Project ref: EN010159  
Date: 7 May 2025

### **Application by One Earth Solar Farm Ltd for an order granting development consent for the One Earth Solar Farm**

#### **Request for further information**

PROJECT	One Earth Solar Farm
DRAWING TITLE	Representative Viewpoint Locations [EN010159/APP/6.20/11.10]
CLIENT	One Earth Solar Ltd.

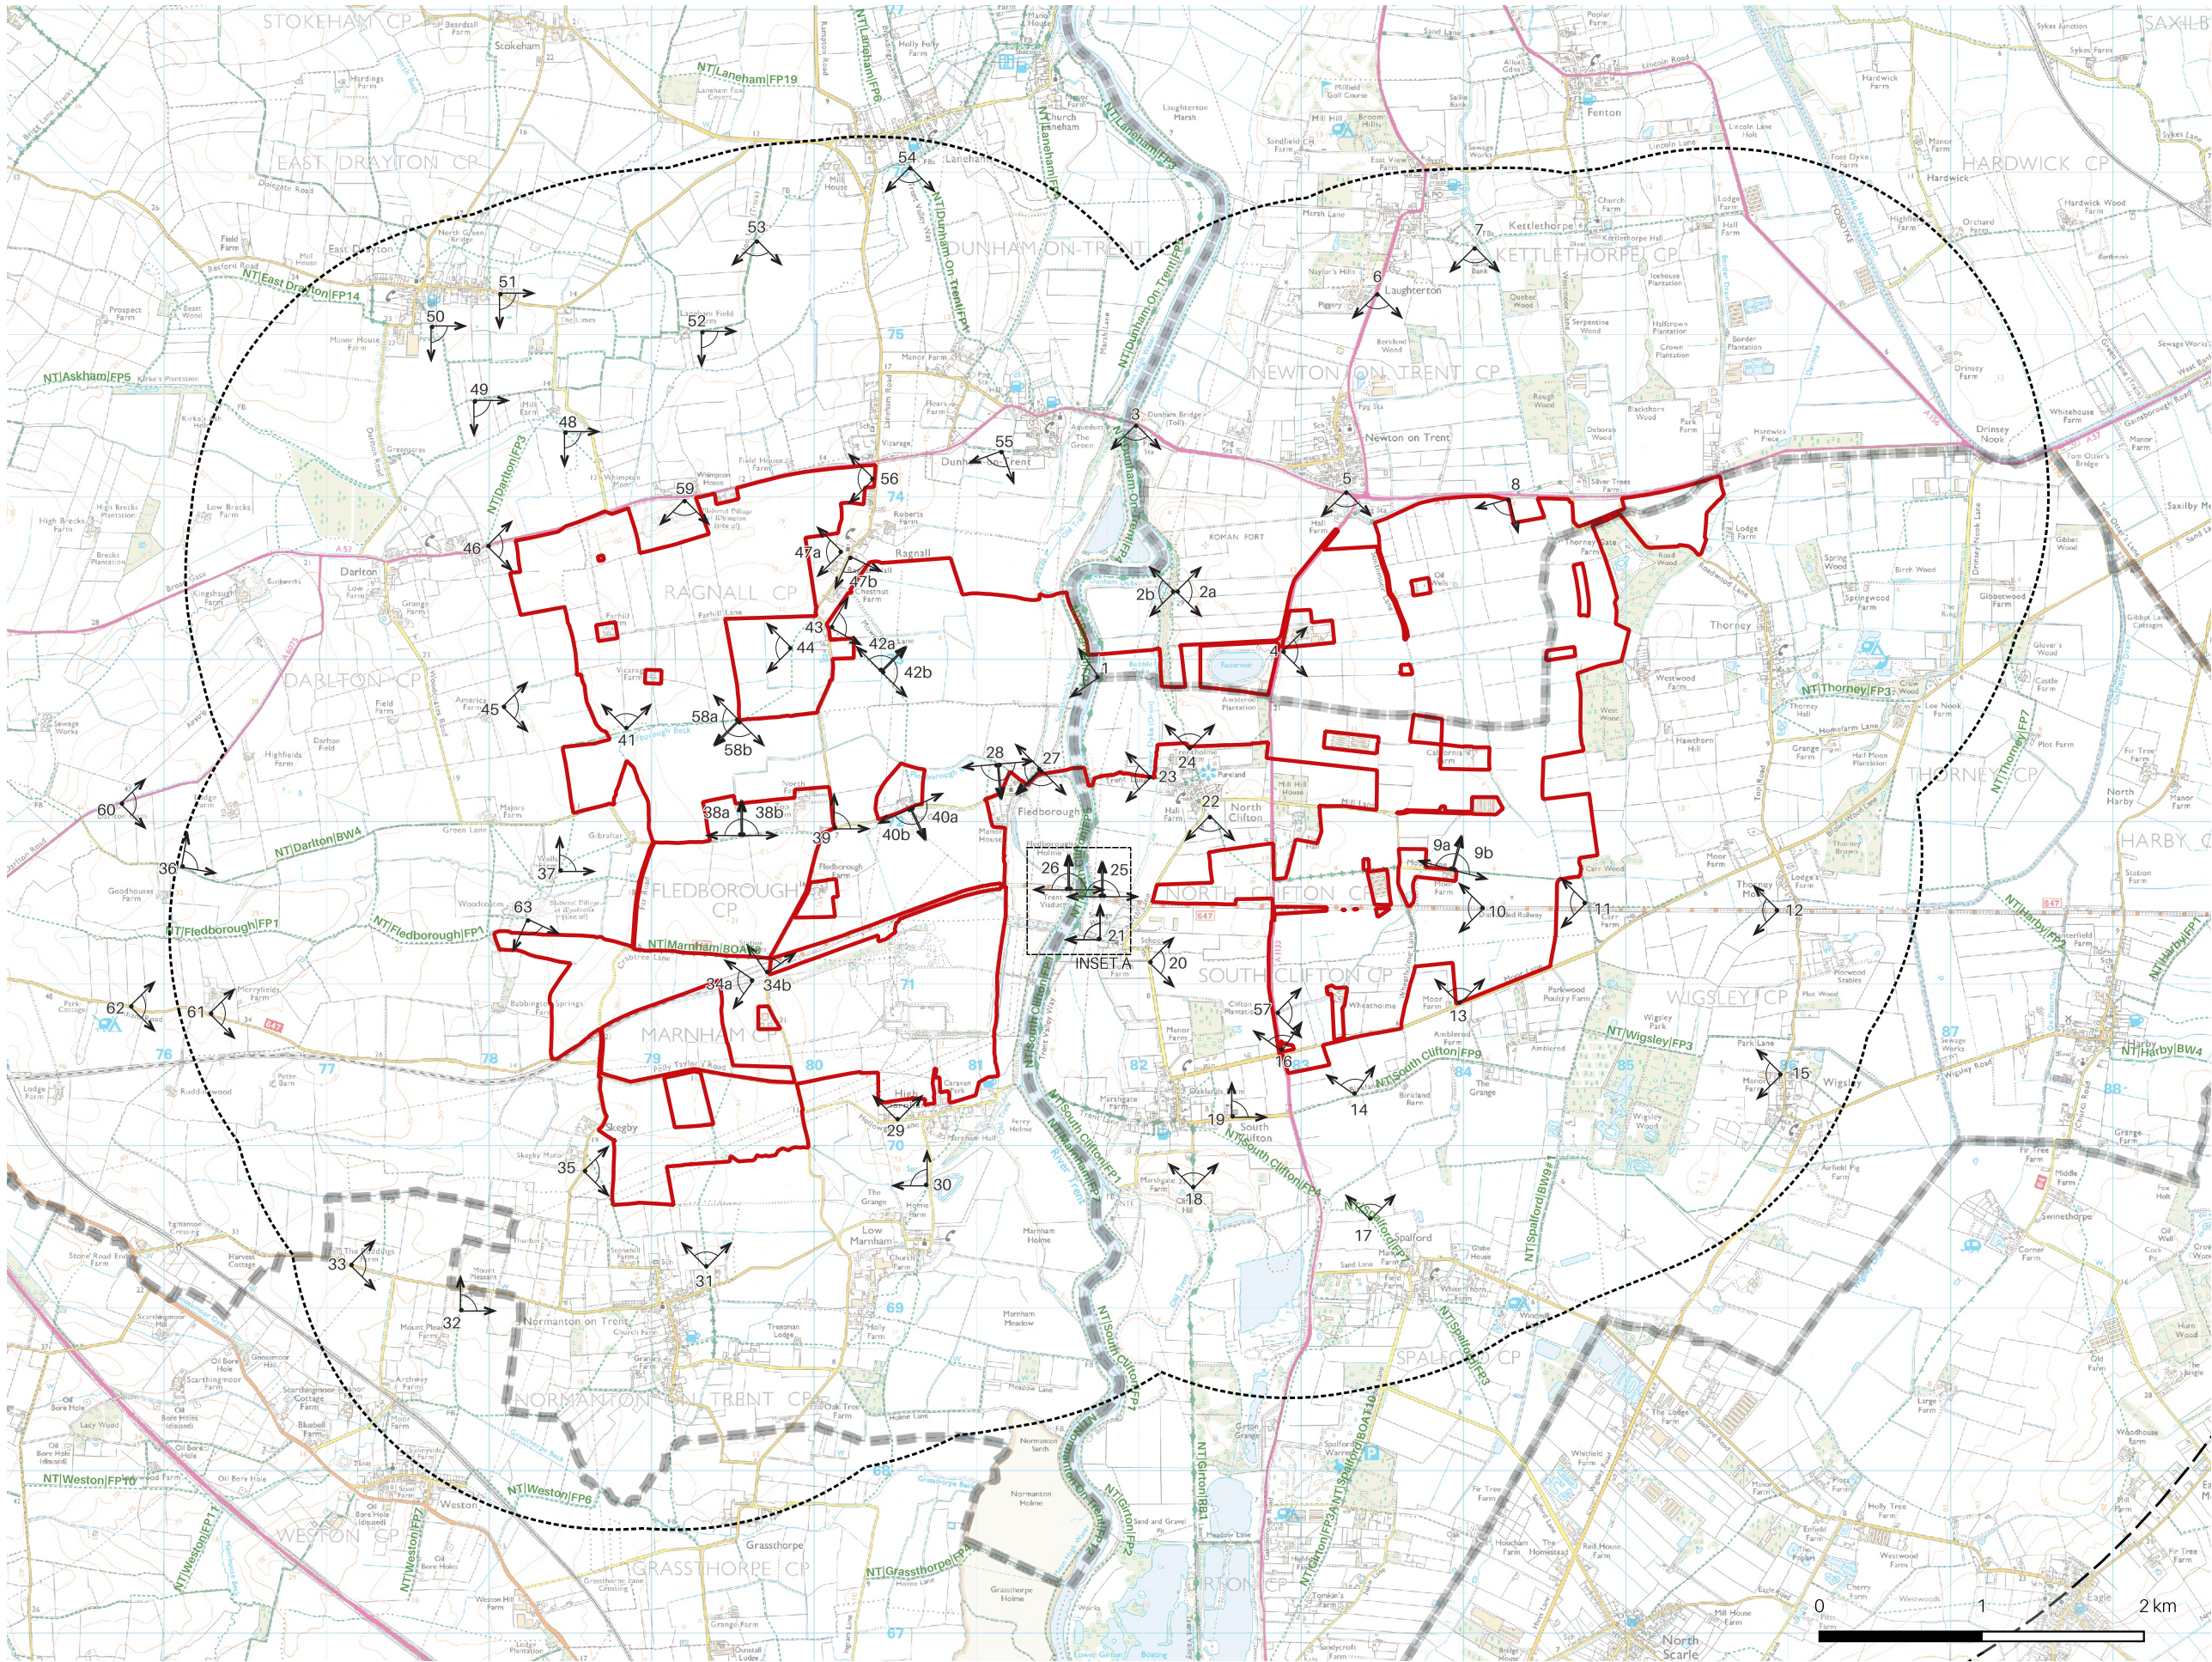
In seeking to understand this Chapter further please point out to the ExA where the plan can be found which identifies the individual viewpoint locations, and the sensitive receptors identified in respect of the landscape chapter.
